Consultation Response from KC, Conservation and Design
2020/92307 Penistone Road/, Rowley Lane, Fenay Bridge, Huddersfield, HD8 0JS
Outline application for erection of residential development
Date Responded: 14/12/20
Responding Officer: Craig McHugh
Responding Ref: KB5/142
Summary

**Figure 6: Viewsheds from points adjacent to 1 Woodsome Road**

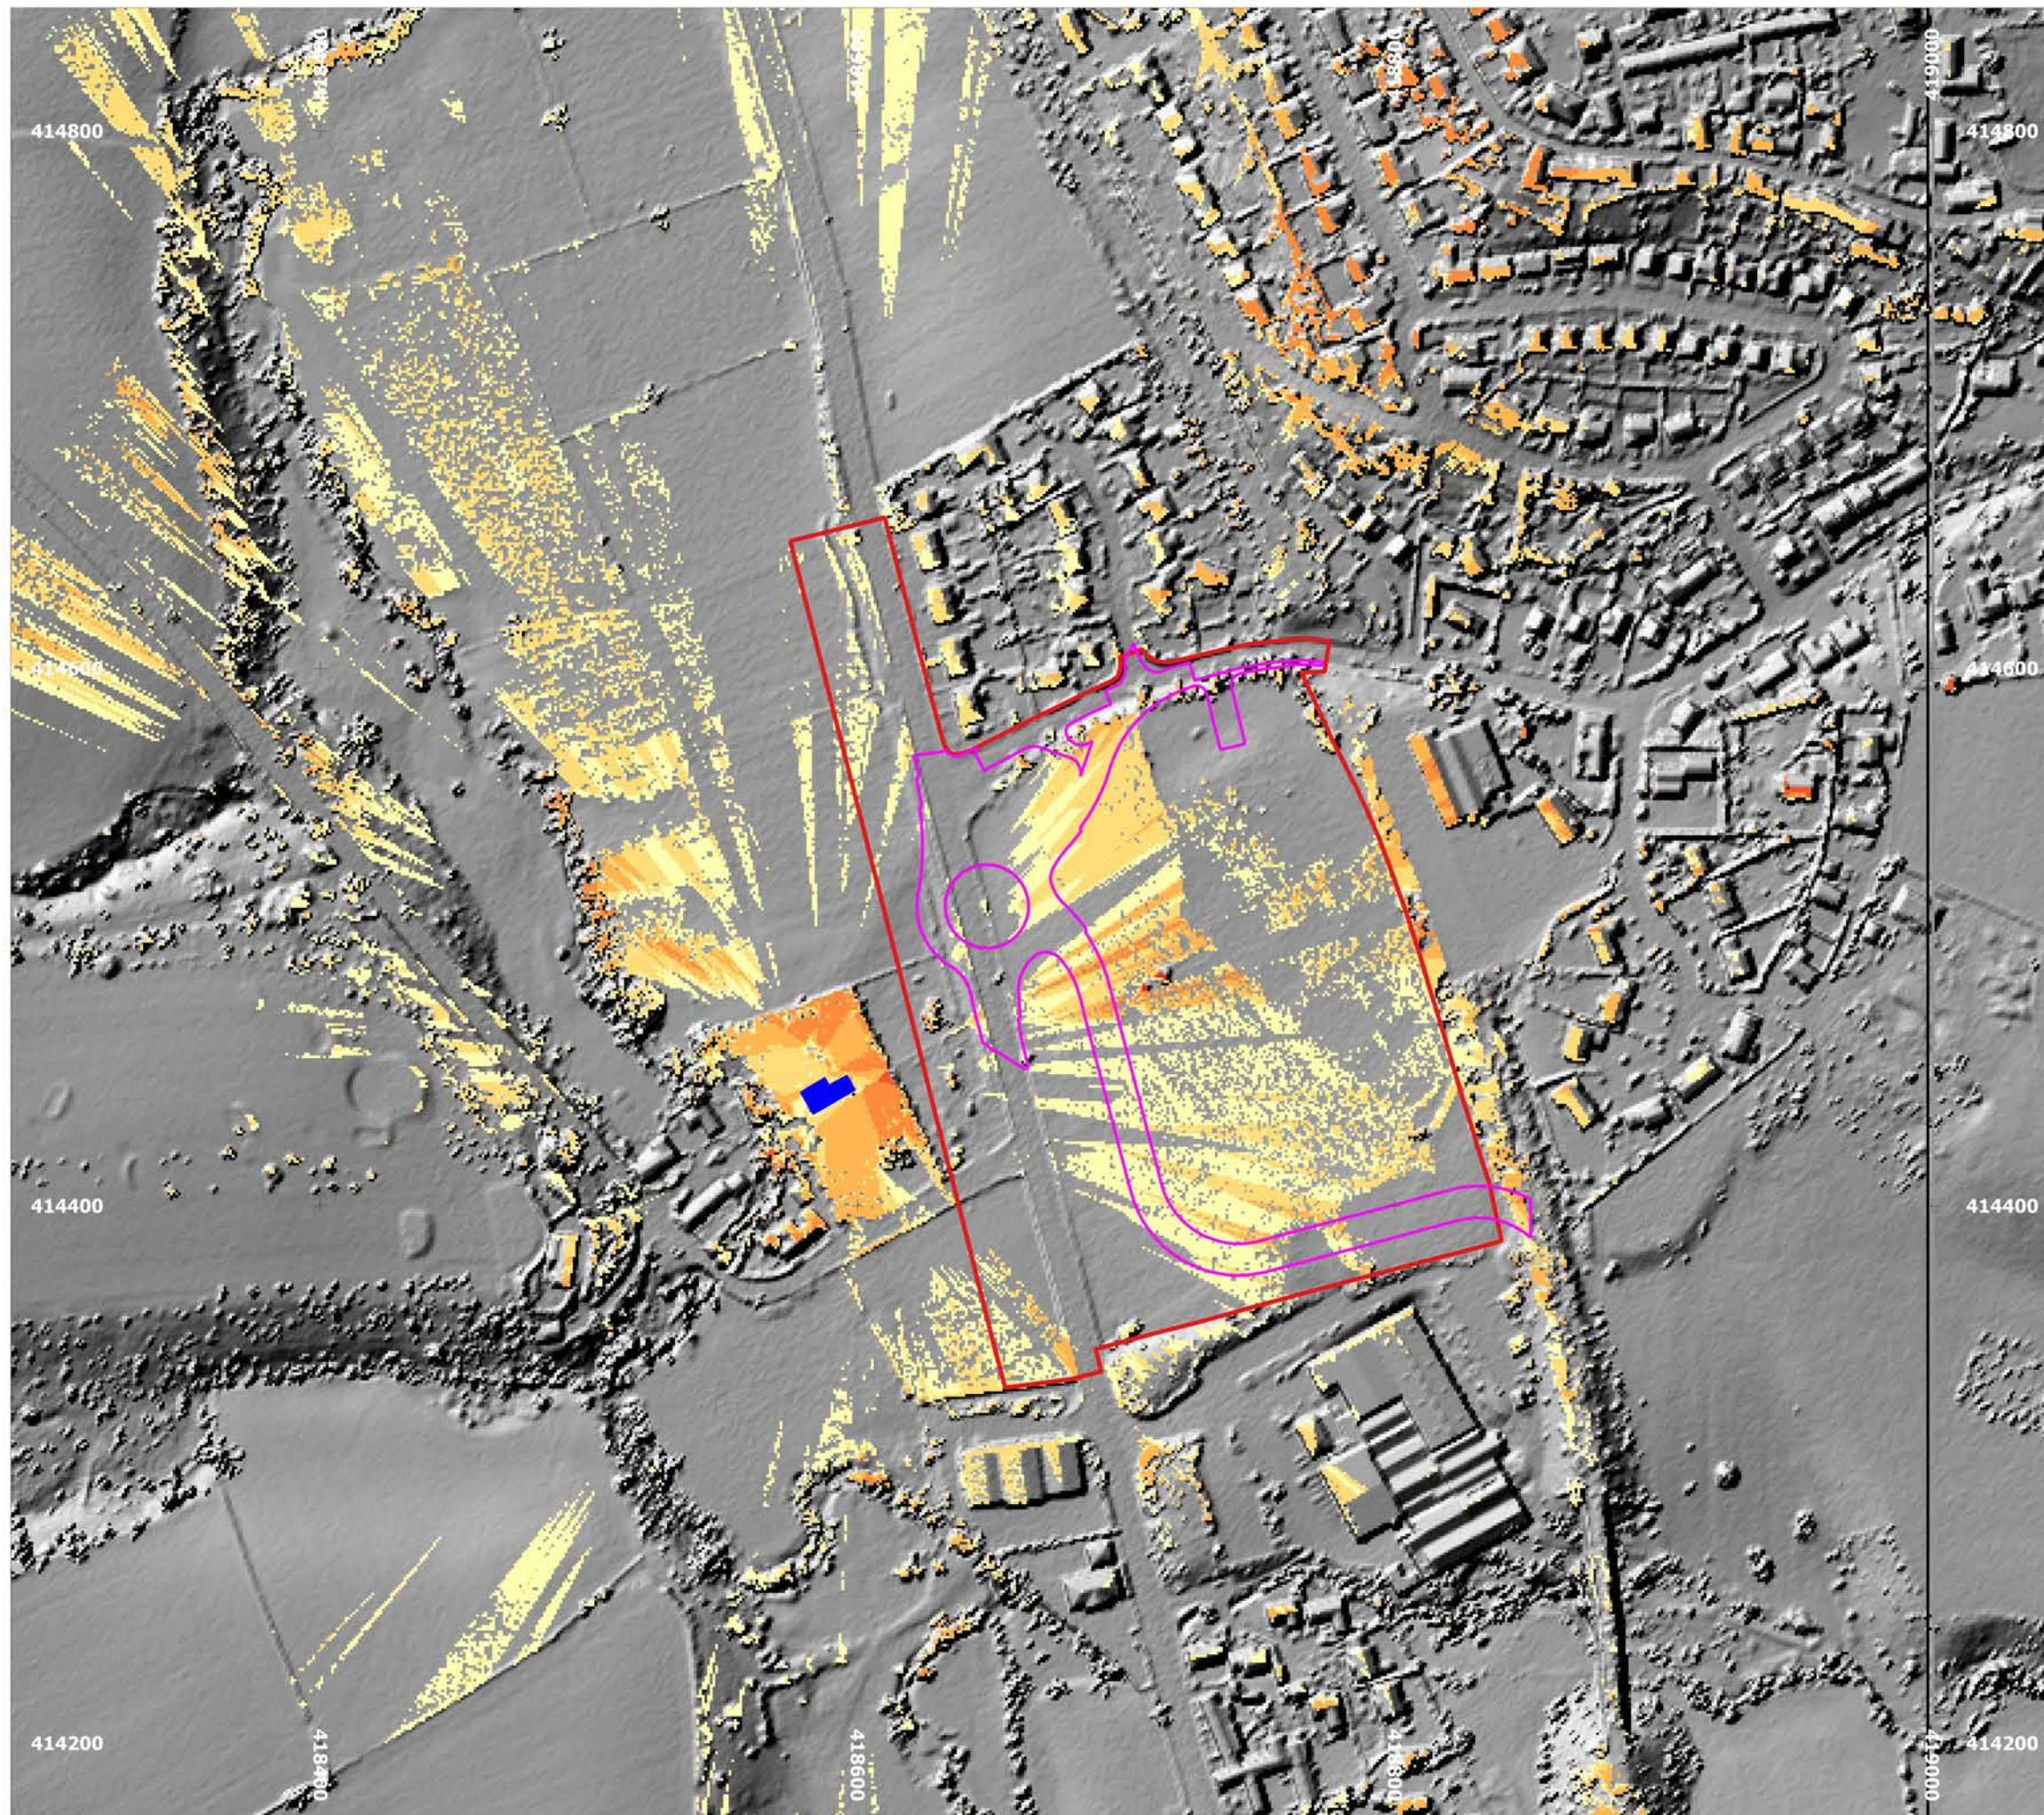
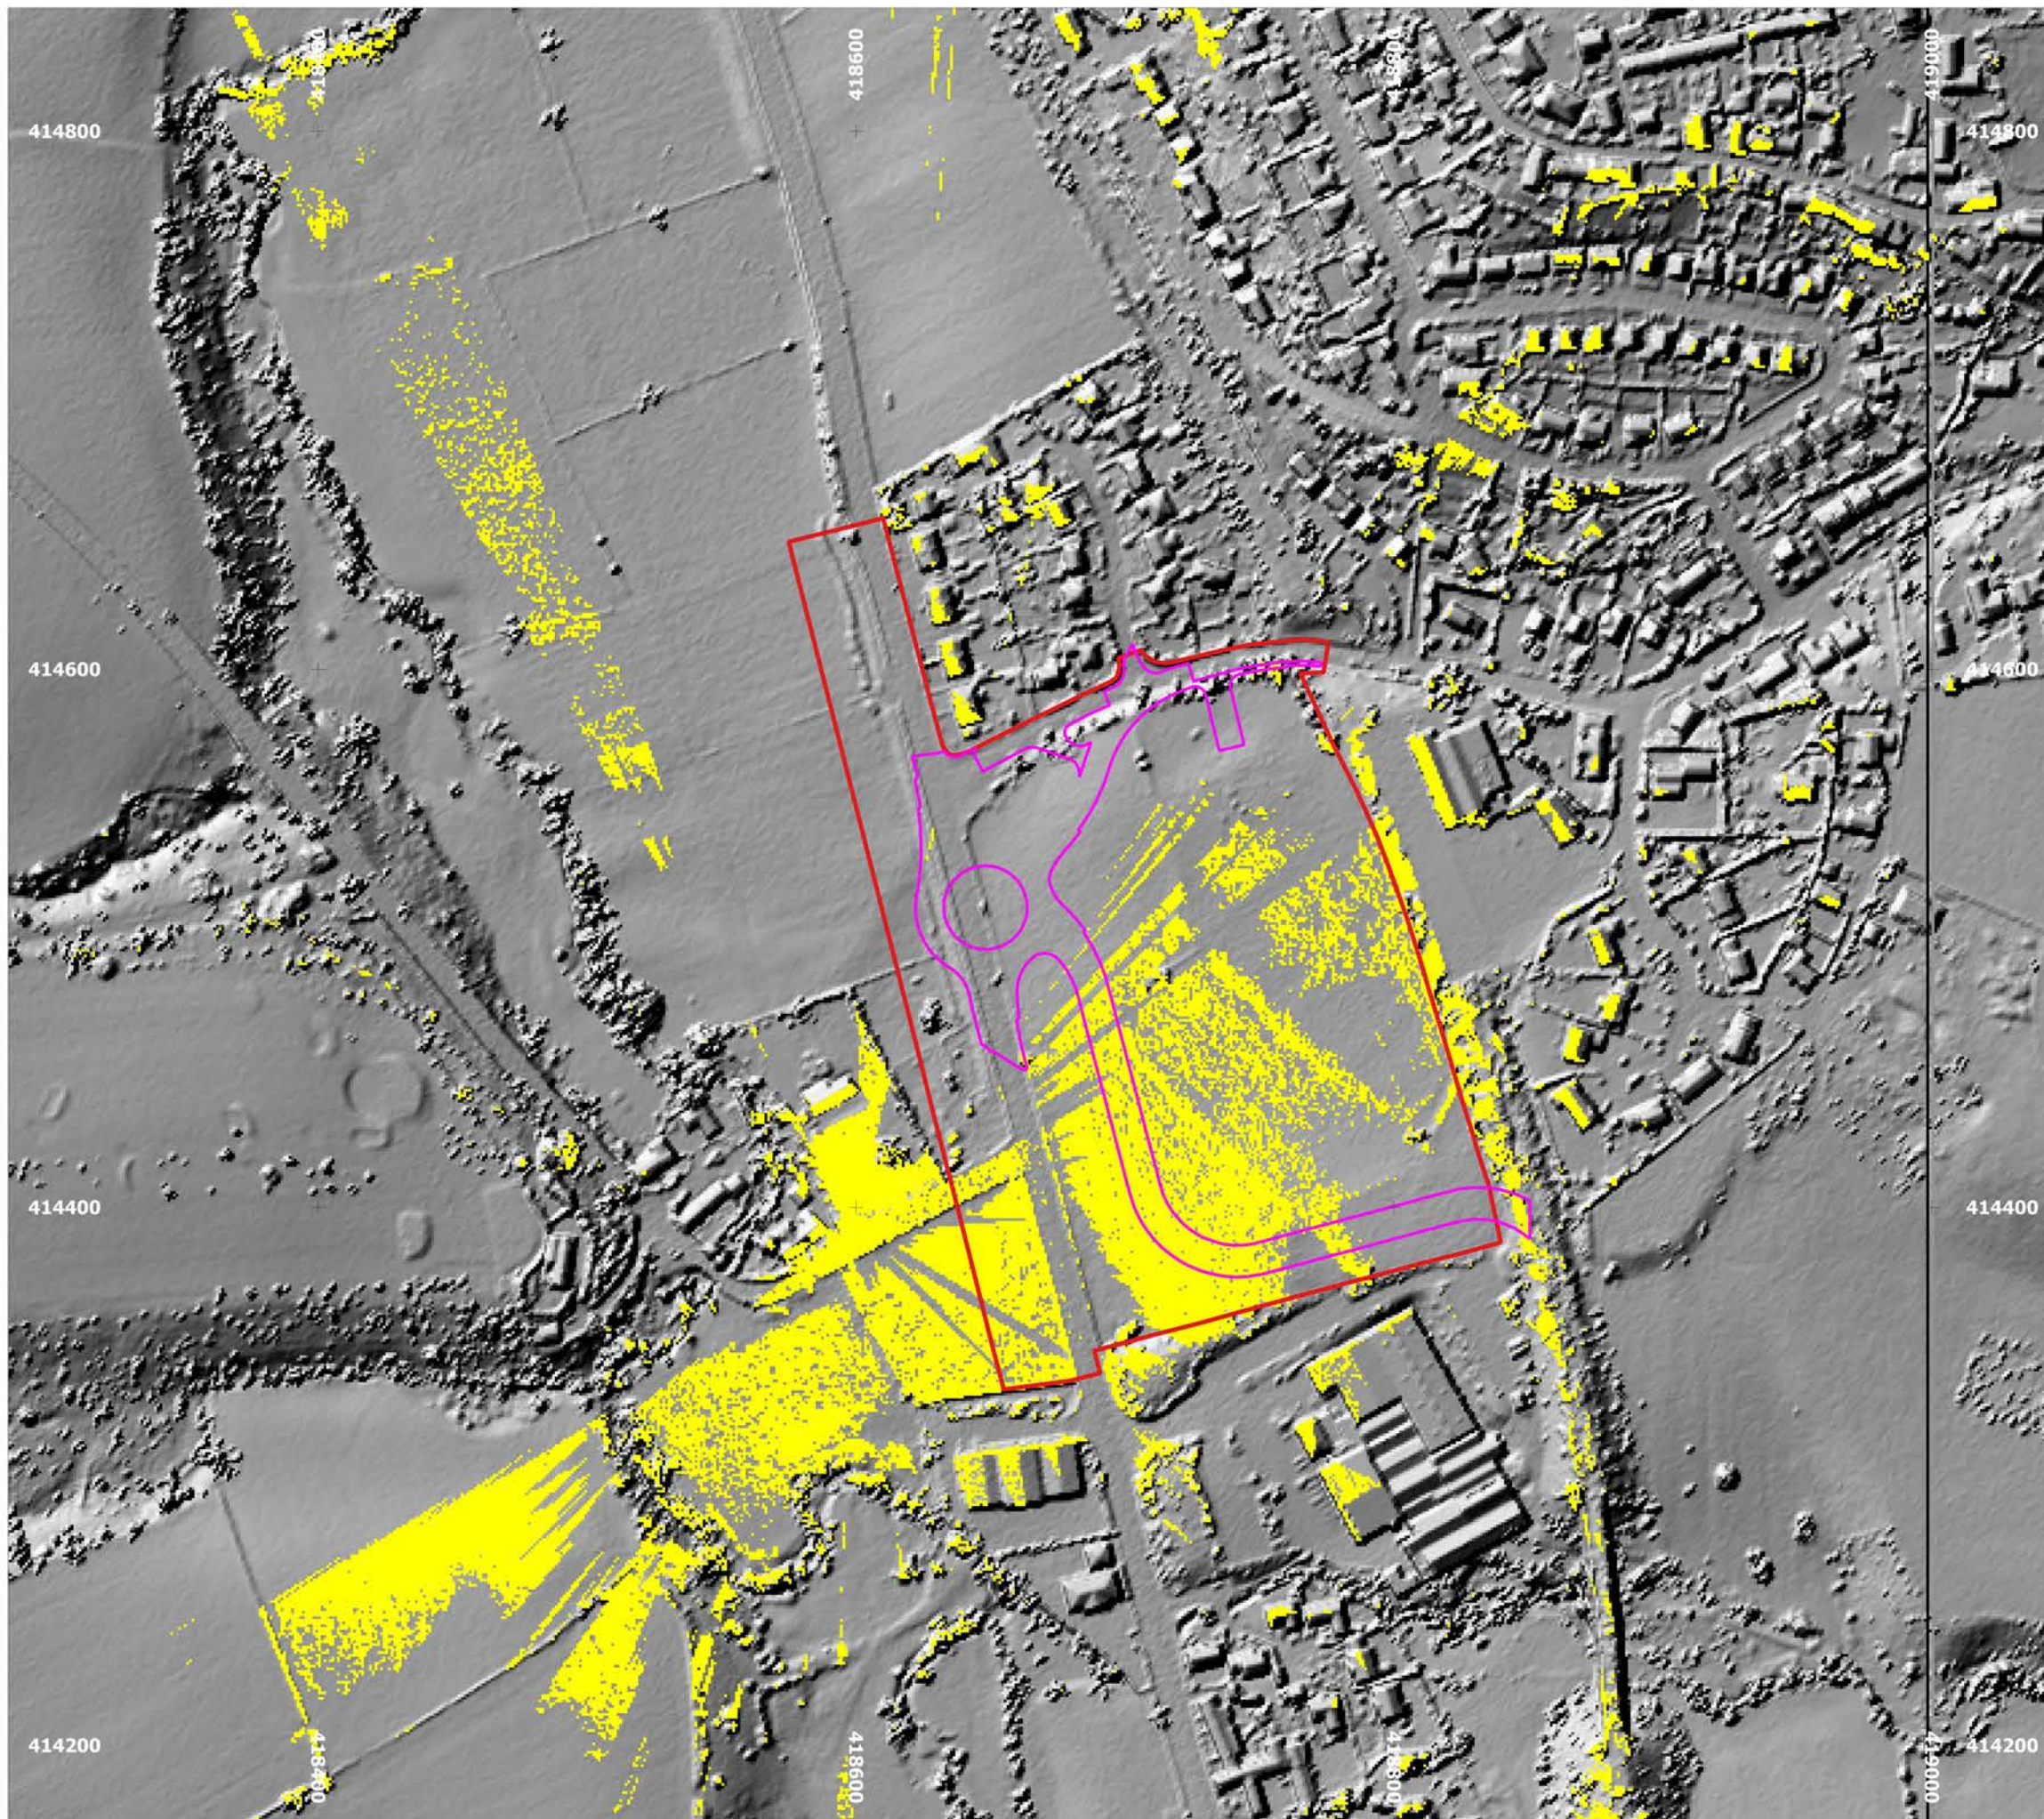
It is evident that the indicated roundabout would cause harm to the setting of 1 Woodsome Road due to the intrusion of the roundabout and associated lighting and traffic into a parcel of land that *contributes to* its setting. Visual impact assessment is also needed to evaluate the extent of the adverse impact and plan for the necessary mitigation for this designated heritage asset.

The submitted Heritage Statement only considers the impacts on Woodsome Hall, it does not consider impacts on 1 Woodsome Road, which is clearly affected by the roundabout proposal and the development of HS2. Visual impact assessments are also needed.
